**Rix's Creek Continuation Project (SSD 6300) - Response to Applicant's response to the Independent Planning Commission Review and Draft Conditions of Approval**

I refer to the Department of Planning and Environment – Resources Assessments (DPE – Resources & Assessment) email dated 10/12/2018 inviting the Resources Regulator to provide advice on the Applicant's response to the Independent Planning Commission Review and provide Draft Conditions of Approval for the Rix's Creek Continuation Project.

**19 December 2018**

Attachment 4: DP& E Item 5 – Final Landform - Option 2 Figure 1-2.

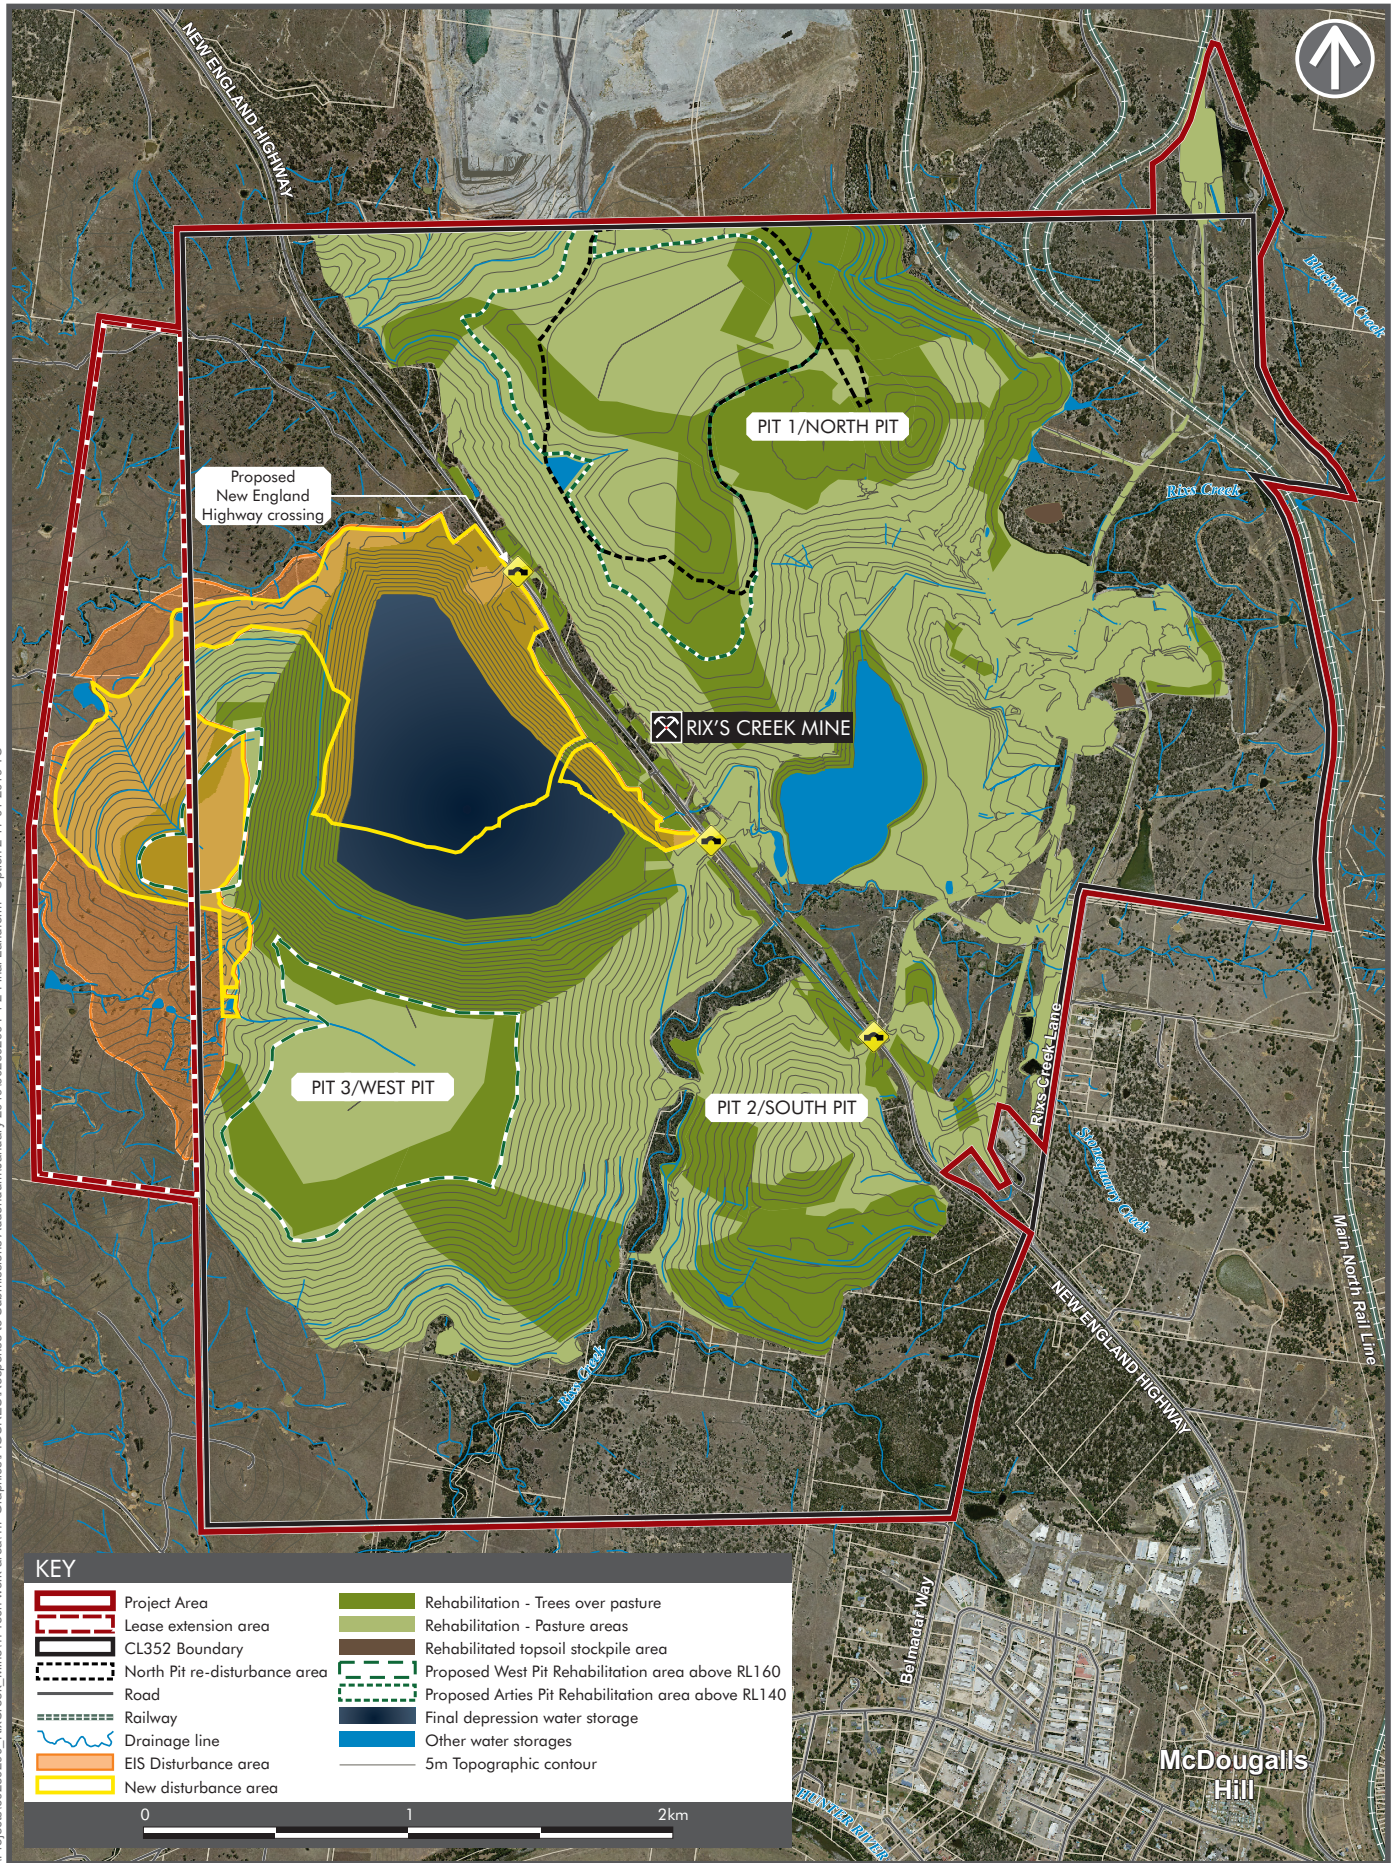
*The Applicant must rehabilitate the site to the satisfaction of the Resources Regulator. This rehabilitation must be generally consistent with the proposed rehabilitation activities described in the document/s listed in Condition 1 (and conceptually shown in the figure Appendix X (insert final landform figure of ‘Option 2’)), and comply with the objectives in Table X.*
